**Application No: SSD-83258708**  
**Property: 29 Florida Street, Sylvania**  
**Proposal: Construction of 8 residential flat buildings containing a total of 484 dwellings across two stages (including 159 residential apartments for the purpose of affordable housing)**

Thank you for the opportunity to comment on the State Significant Development (SSD) application (SSD-83258708) for the above residential development including affordable housing at 29 Florida Street, Sylvania.

GA - OVERALL - LEVEL 04

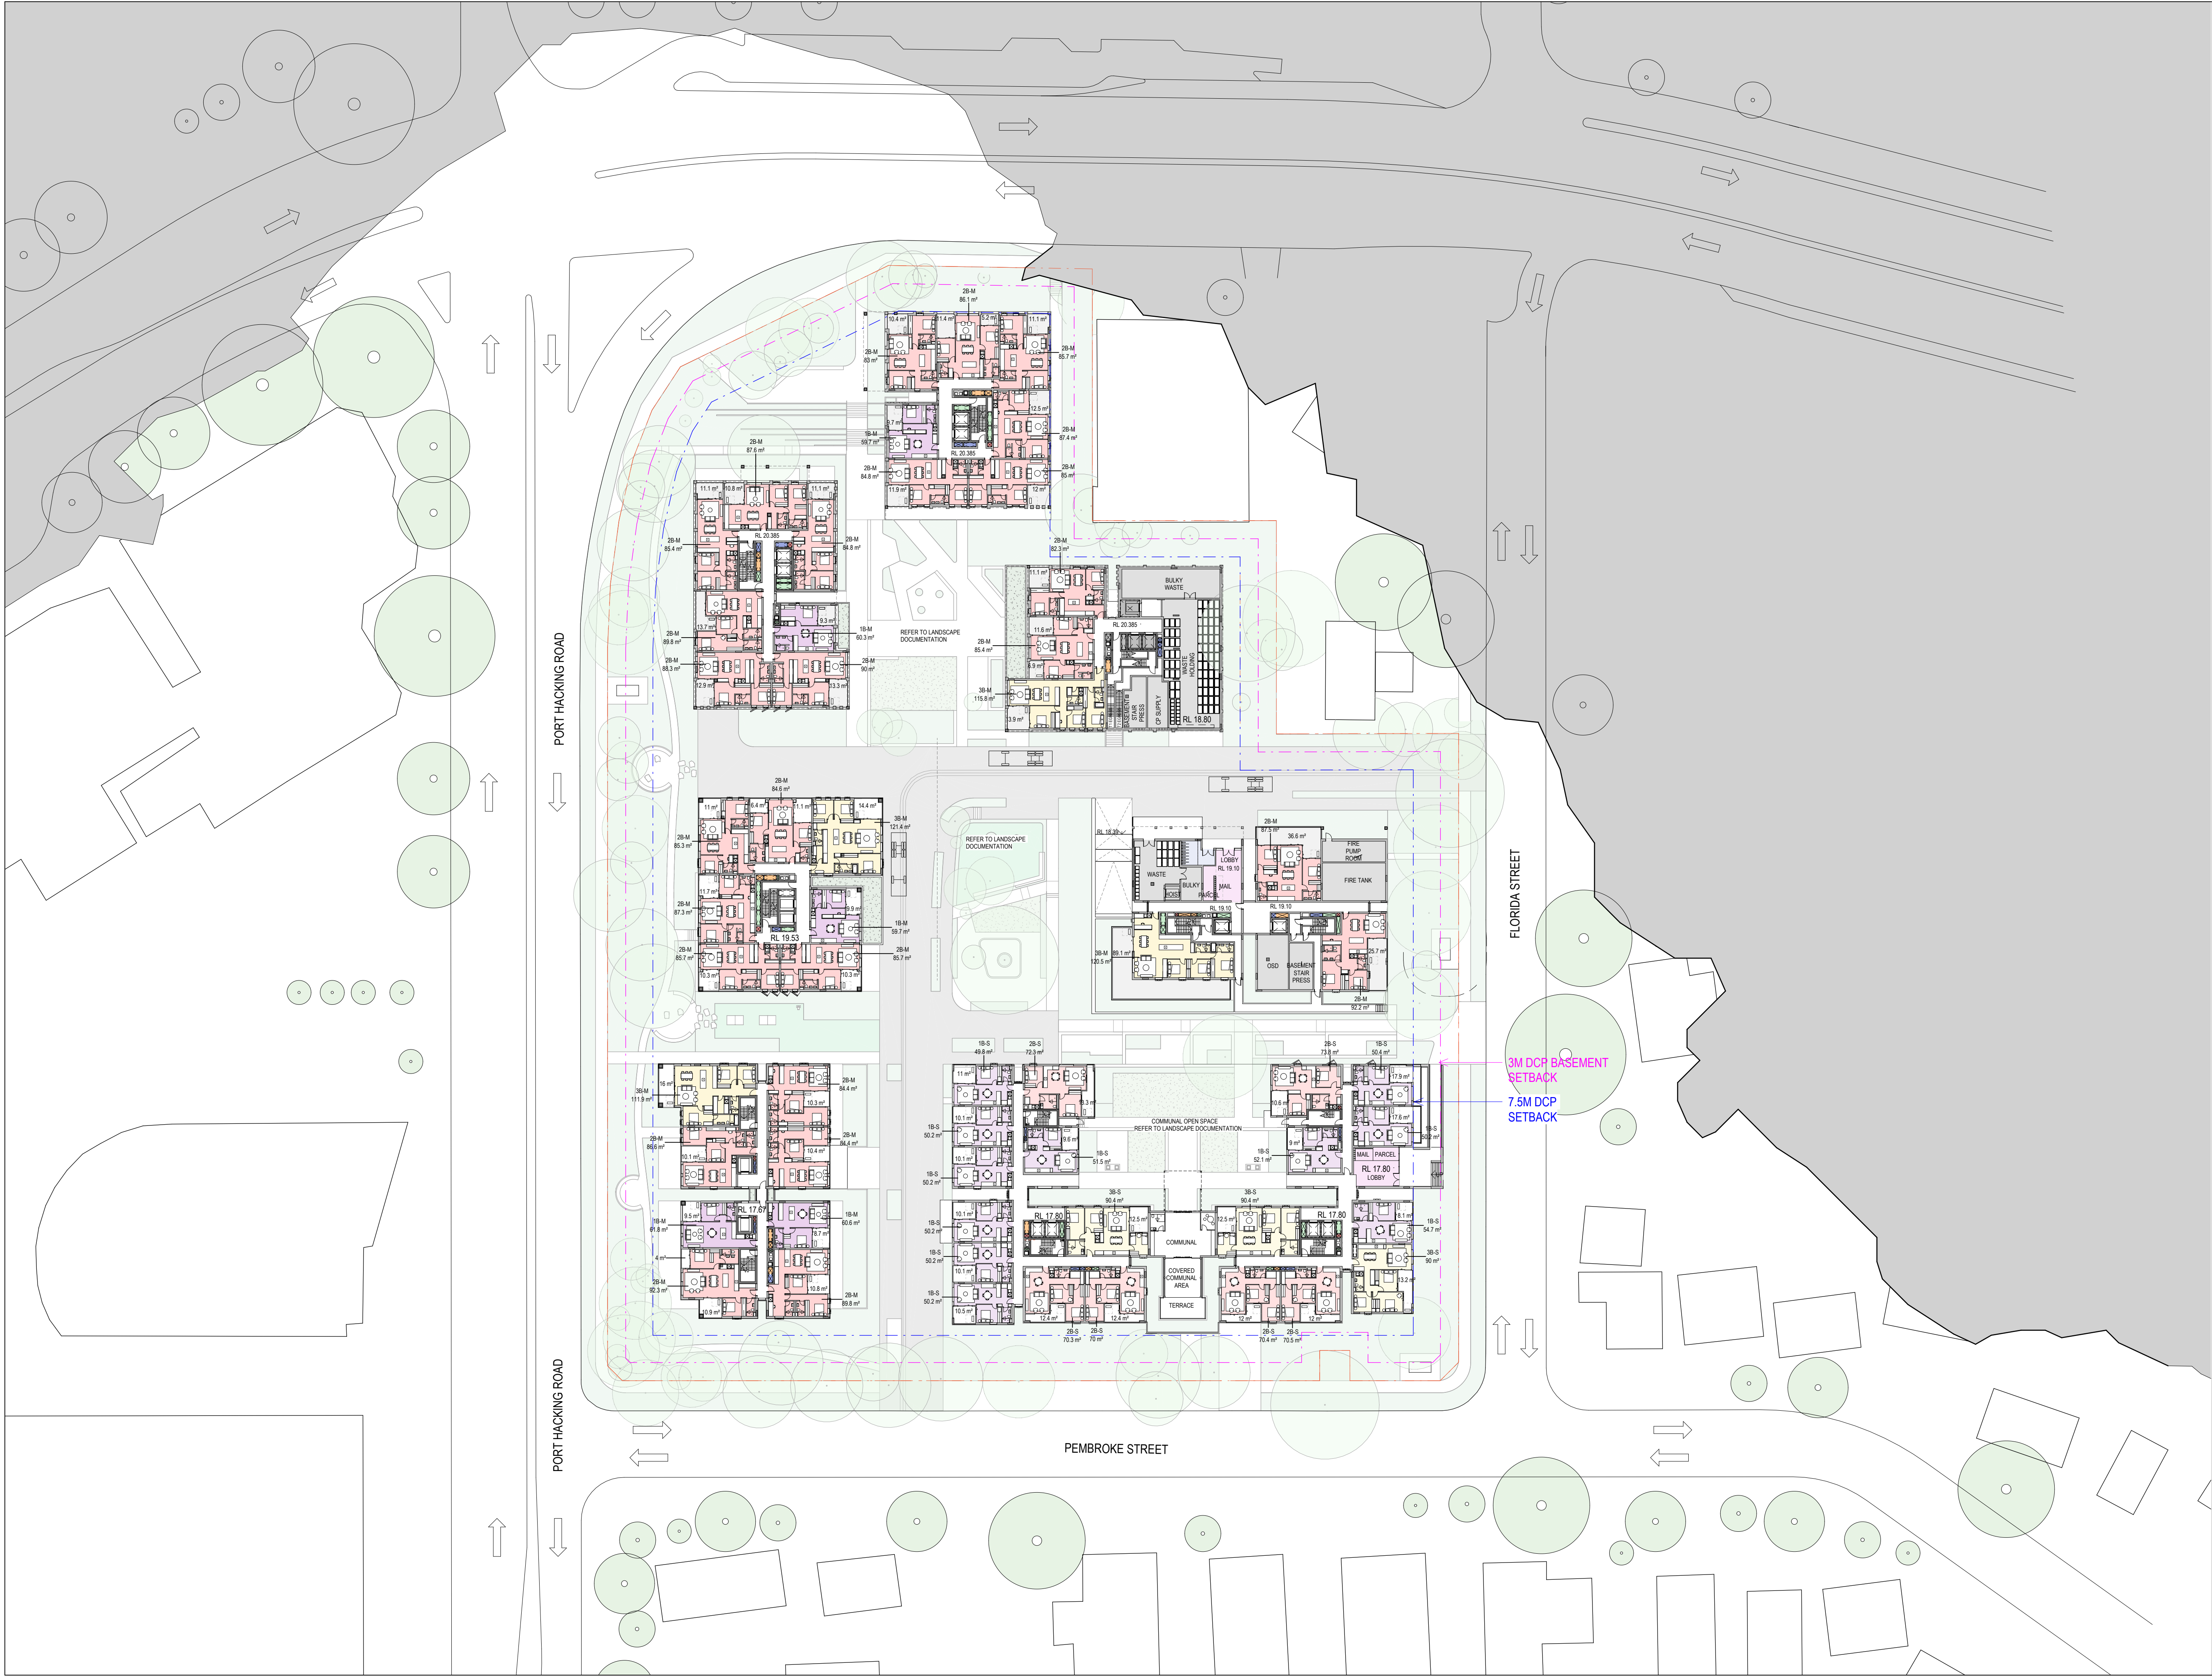
- The western lobby of the Social housing building appears to lack an accessible entry - only steps are provided.

- The elevated ramp adjacent to building 1A results in direct overlooking into the private open space and habitable rooms of the adjoining units, compromising residential privacy and amenity.

- A foot path elevated above the ground floor level of building 3B is positioned hard up against residential units, compromising the privacy of bedrooms and living areas.

- To realise the design intent outlined on page 30 of the Design Report (Porous and Permeable), the east-west oriented pedestrian path between building 1A and 3A should be extended to provide a direct connection to Port Hacking Road.

SUN EYE VIEW

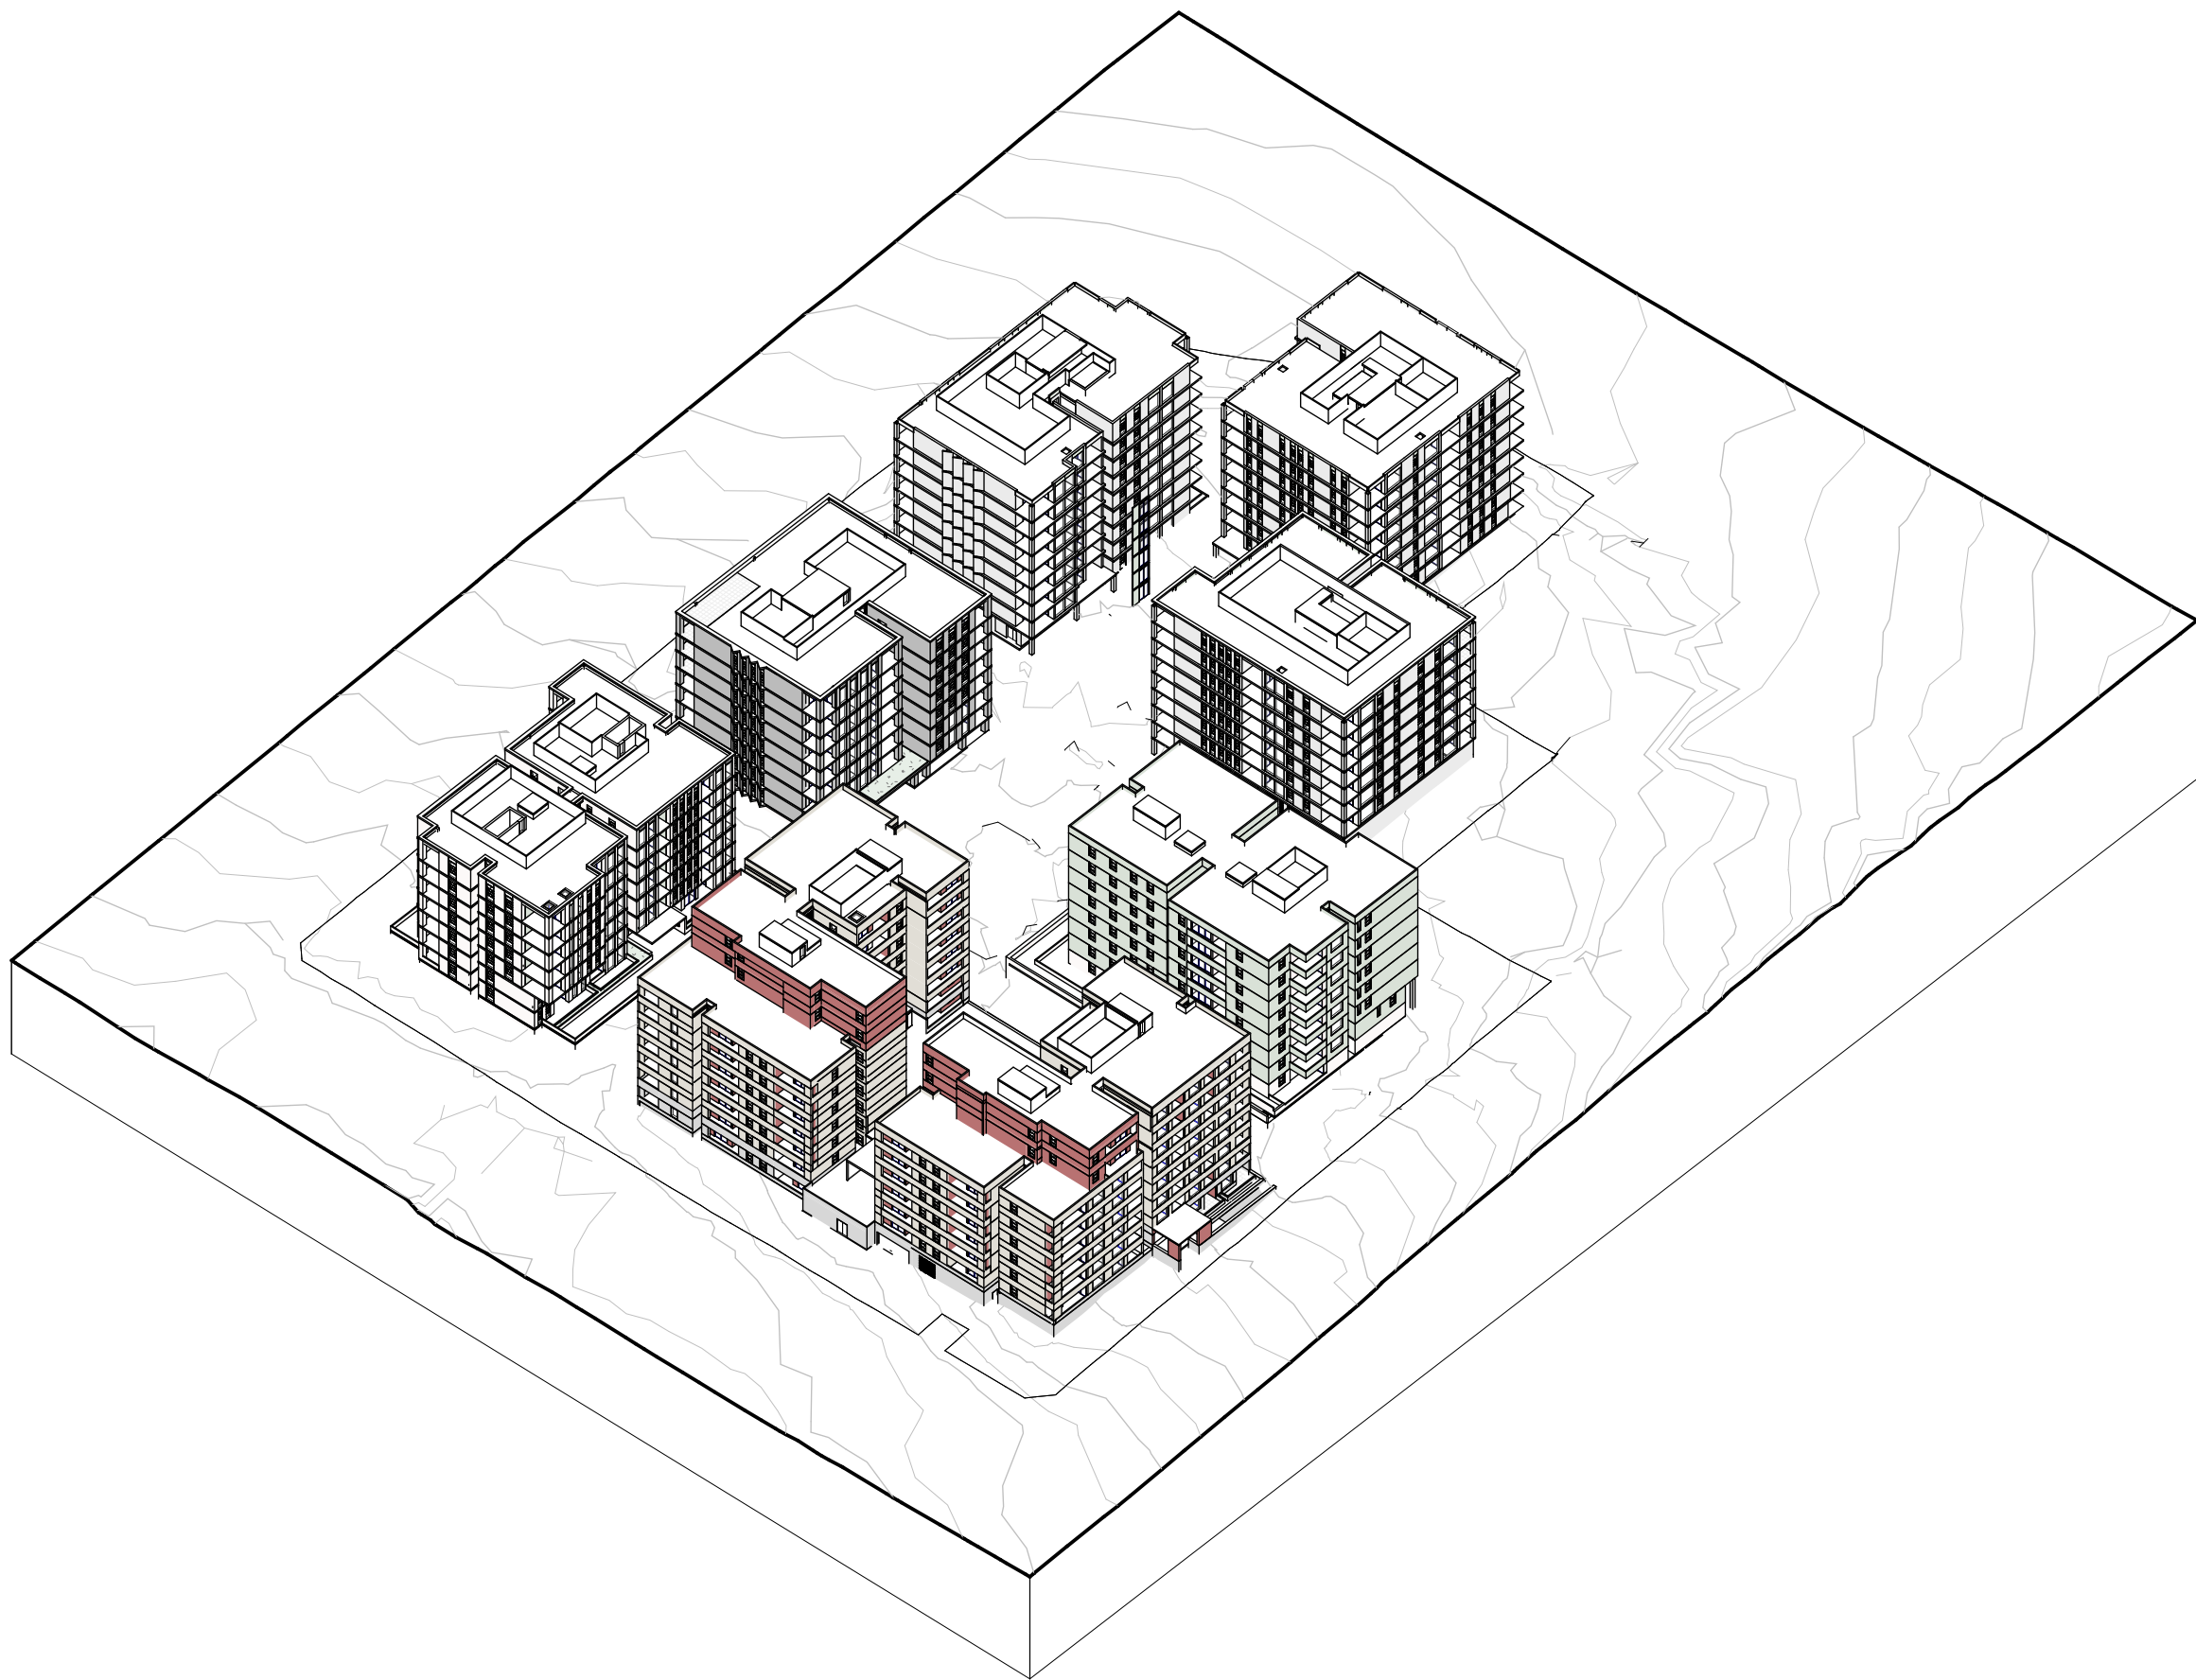
A 'Sun-eye Views' plan accompanies the application which demonstrates the southern edge of the social housing building (that does not comply with the maximum height control) will dictate the extent of shadow cast by the proposal. Figure 2 below is an extract from the architectural plans which demonstrates that at 12pm, 21st of June, the non-compliant upper-level is the primary contributor to overshadowing of the southern adjoining properties.

The solar access diagram provided in the Design Report by BVN (pages 69 and 70), indicates that the height contravention will not impact solar access to the residential properties on the southern side of Pembroke Street. This contradicts the sun eye view diagrams provided in the architectural drawing package and as such, the extent of overshadowing to properties south of the site has not been accurately or consistently documented. Given the significant increase in height provided by height bonuses, the transition to a lower scale residential zone and the proposed height non-compliance, it is essential that the proposal is informed by an accurate and comprehensive solar access study.

The extent of overshadowing affecting the southern adjoining properties must be clearly and accurately demonstrated. This includes modelling existing buildings, identifying areas of private open space and windows to habitable rooms, and updating sun's eye view diagrams to quantify the duration and extent of overshadowing. The outcomes of this study should be used to further refine the built form of buildings fronting Pembroke Street to ensure an appropriate transition to the adjoining low-density residential context is achieved.

3.1 Precinct Plan — Social Housing & Market Building 2

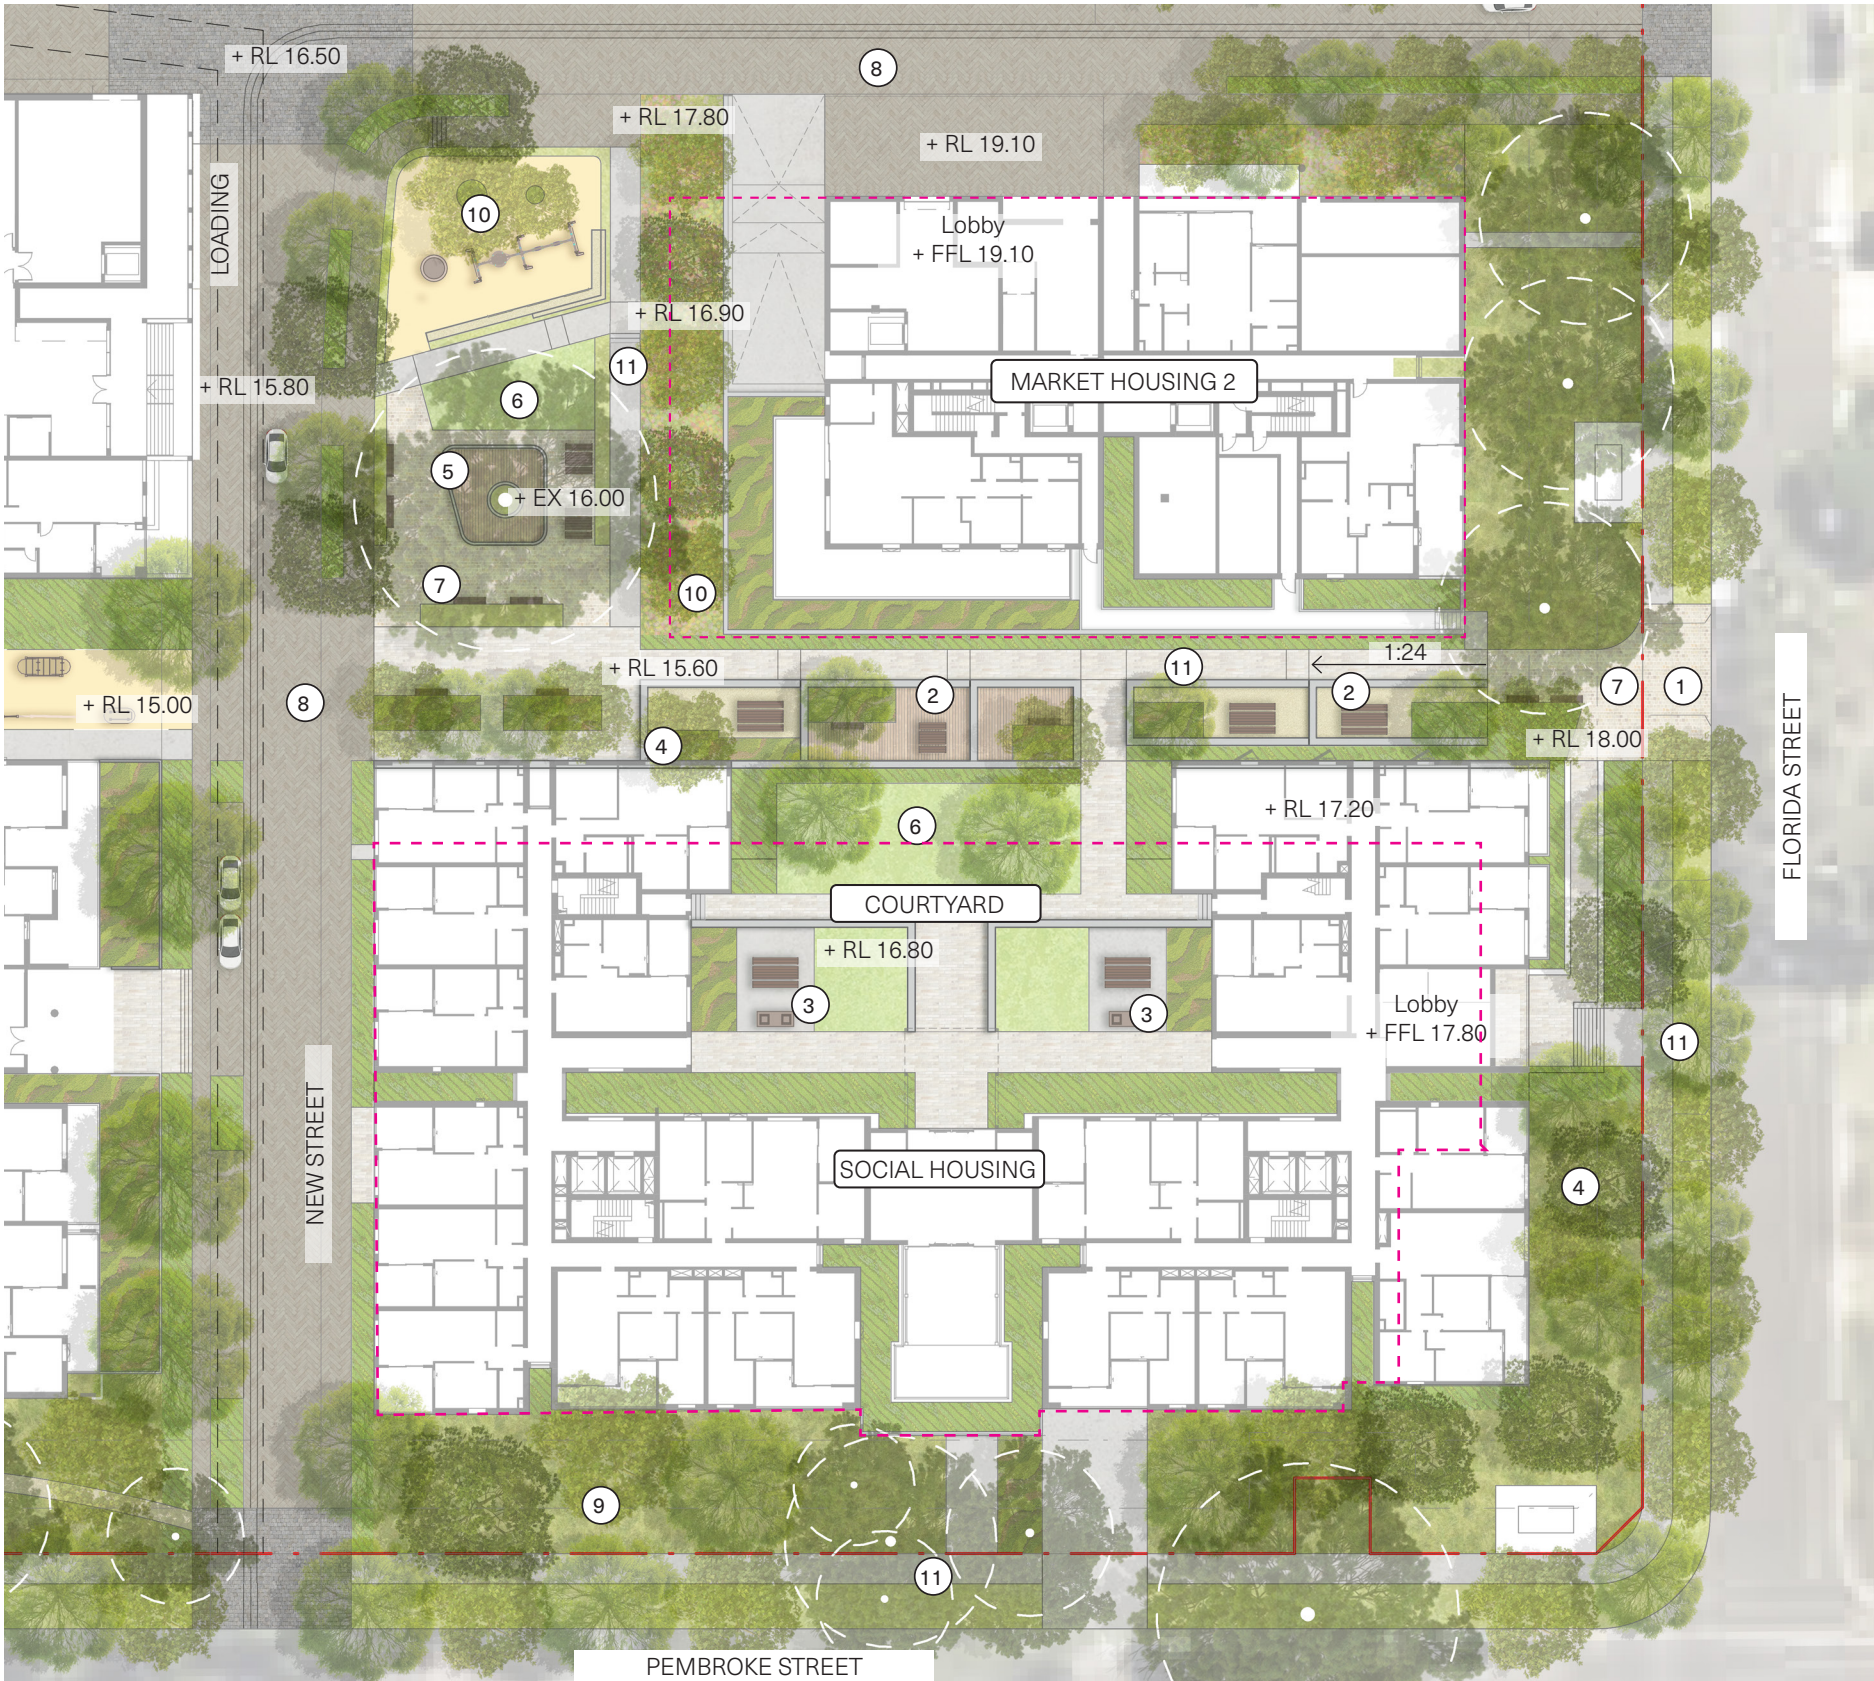
- The BBQ areas within the communal open space of the social housing building are located in close proximity to ground floor dwellings. This arrangement is likely to adversely impact the amenity of future occupants through noise and smoke associated with the use of these facilities.
